May 15, 2017

**Re: APS Family School NW-Work Order
Erosion and Sediment Control Plan
Engineer's Stamp Date 5-8-17 (A09E099)**

D1 TEMPORARY EROSION AND SEDIMENT CONTROL PLAN
SCALE: 1" = 50'-0"

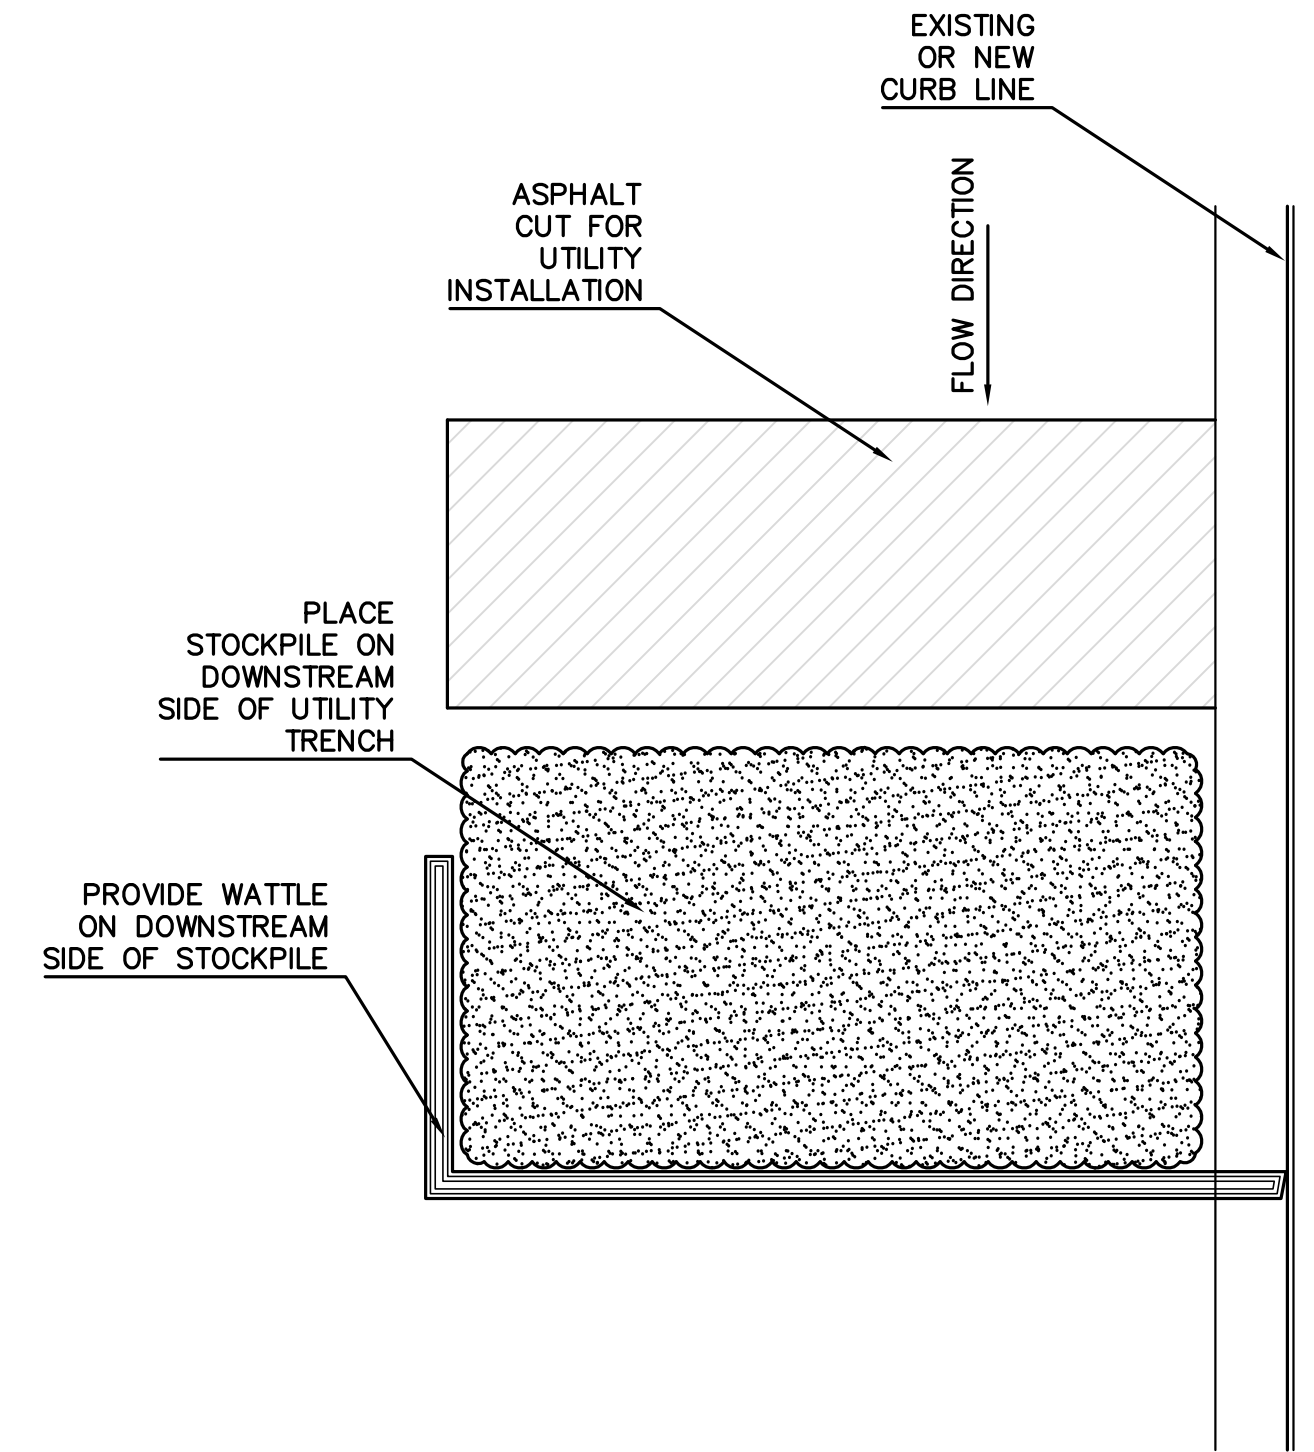
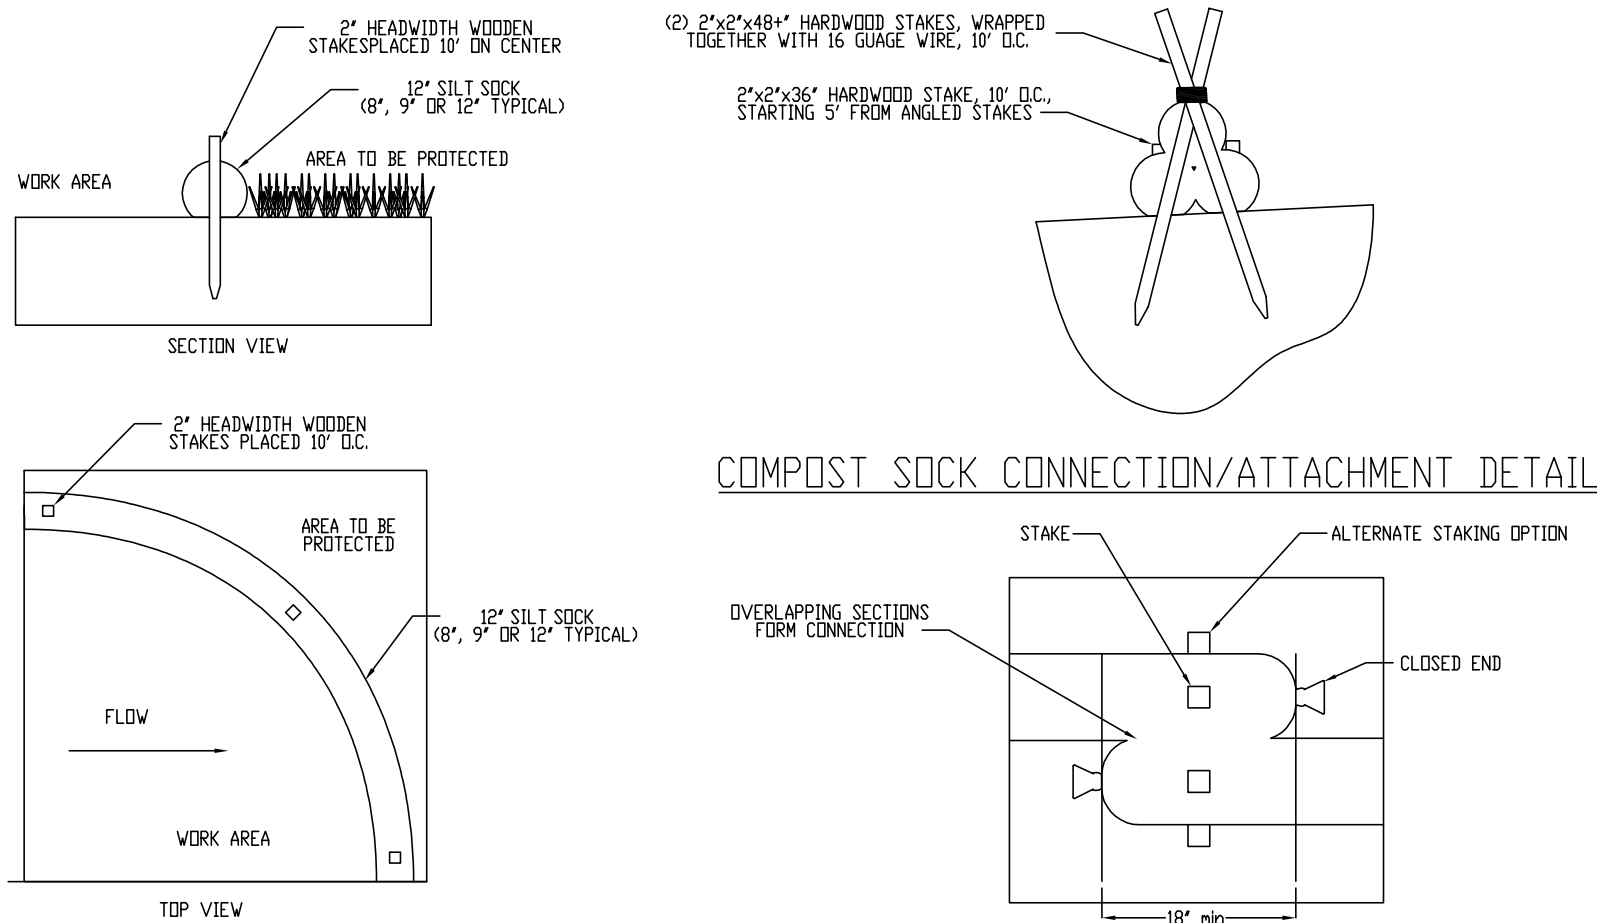
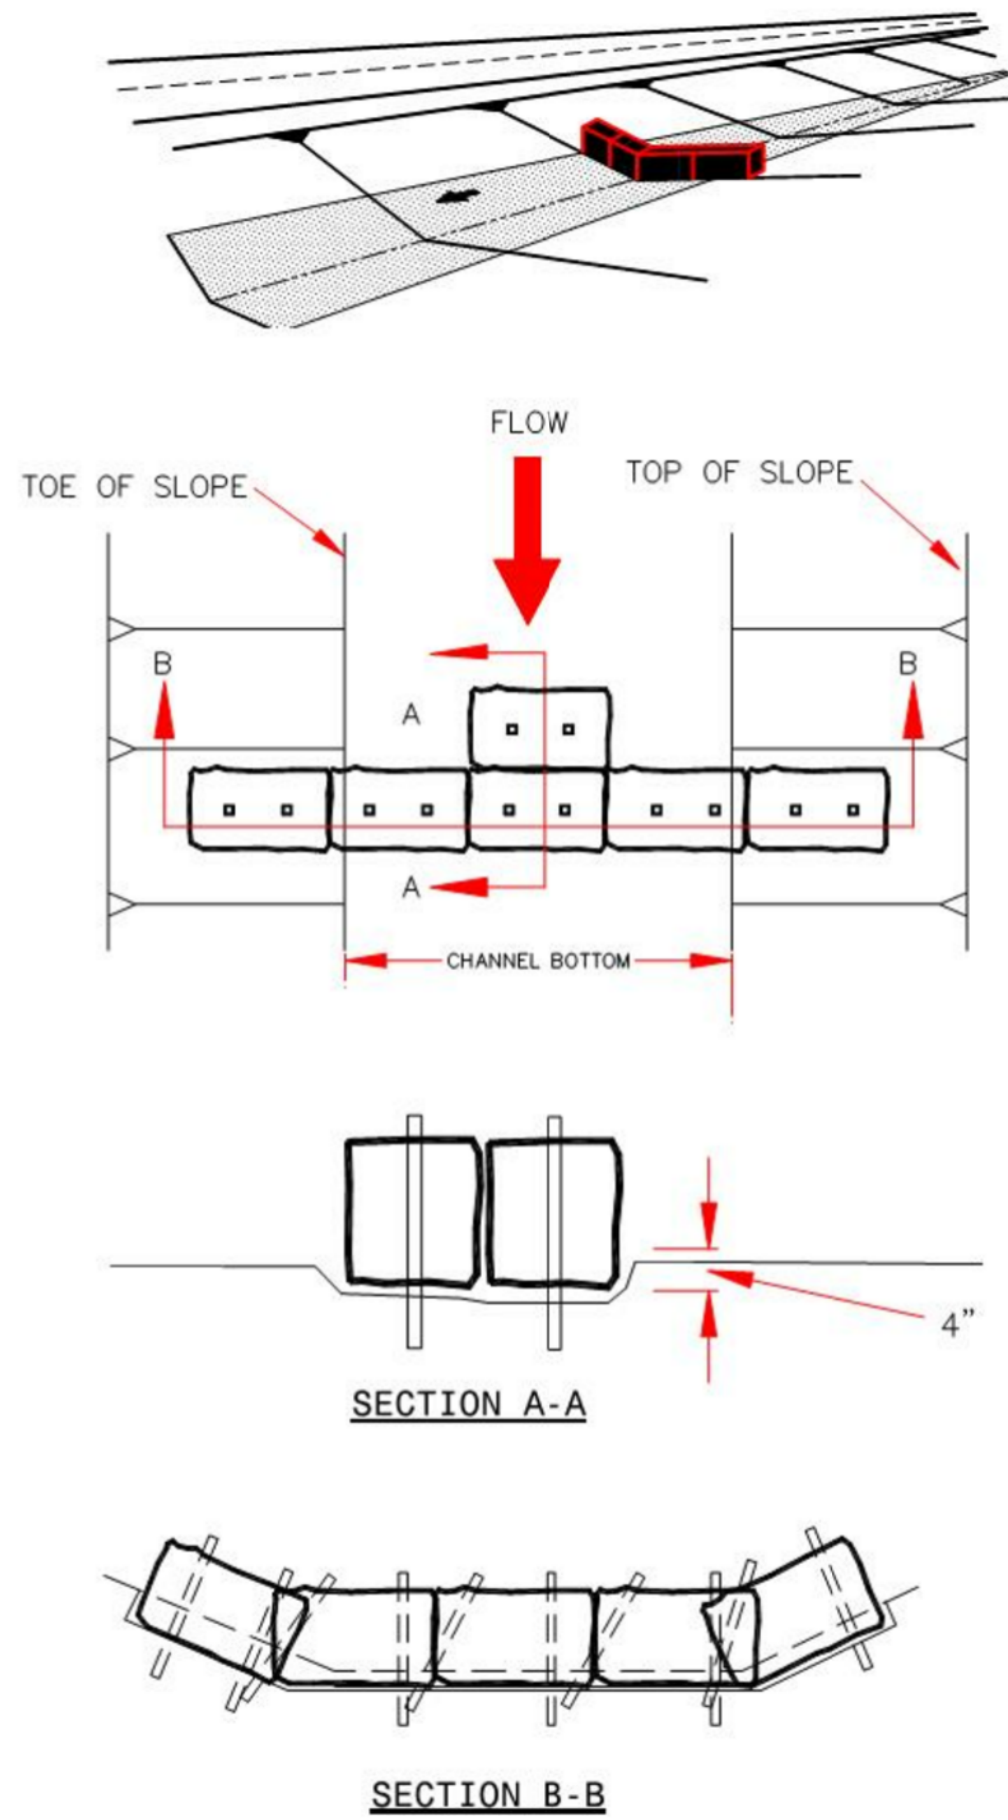
In general, Stormwater Quality does not approve the use of hay/straw bales as they fall apart and become debris. However, in this case, the site has a large dirt/vegetation area downhill from it so it will be a good case to evaluate the use of hay/straw bales.
